13 November 2025

TII24-129857

Re: Application for development of a 110kV Electrical Substation and Grid Connection at Scart Mountain, Co. Waterford

ACP case ref. VA93.323791

Title: N72
Swept Path Analysis
Sheet 10 of 24

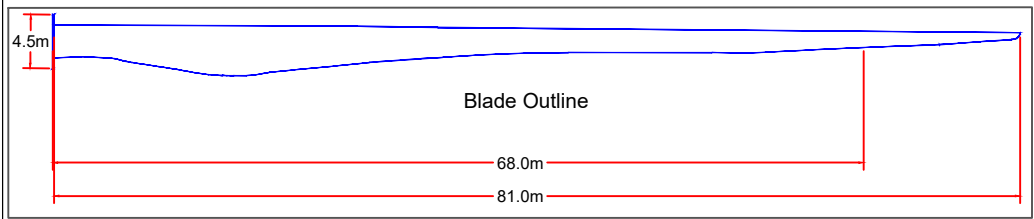
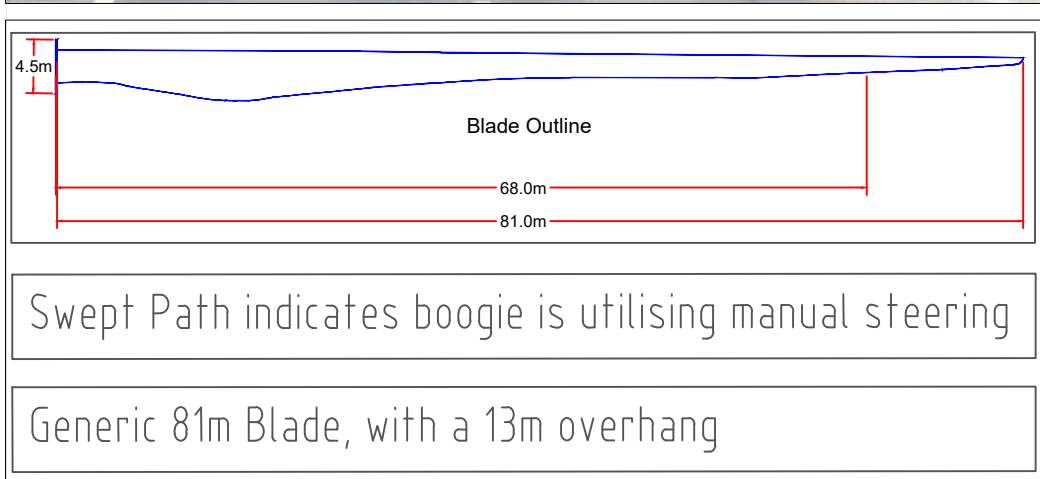
- The proposed temporary works to the N72/L1027 Junction is for a temporary period only to facilitate turbine component delivery and thereafter any temporary access and works removed and lands reinstated. TII considers that any temporary access arrangement should be closed and lands reinstated following completion of the construction phase of development in the interests of road safety and adherence to the provisions of official policy.

- The temporary works to the N72/L1027, national road junction, should be closed off with a temporary safety barrier when not in use for turbine component delivery, as it could be misinterpreted by drivers as part of the roadway. Pending completion of construction, the temporary works shall thereafter be permanently closed and the lands reinstated.

- Any damage caused to the pavement on the existing national road at the access from the N72, national road, due to the turning movement of abnormal loads (eg. tearing of the surface course) shall be rectified in accordance with TII Pavement Standards and details in this regard shall be agreed with the Road Authority prior to the commencement of any development on site.

- It is unclear that the proposed temporary works at the N72/L1027, national road junction, has been subject to Road Safety Audit. Road user safety on the national road shall be safeguarded. A Road Safety Audit should be undertaken and recommendations of the Road Safety Audit shall be incorporated into final designs for construction and the requirements to implement the recommendations of the Road Safety Audit included as a condition on any permission granted.
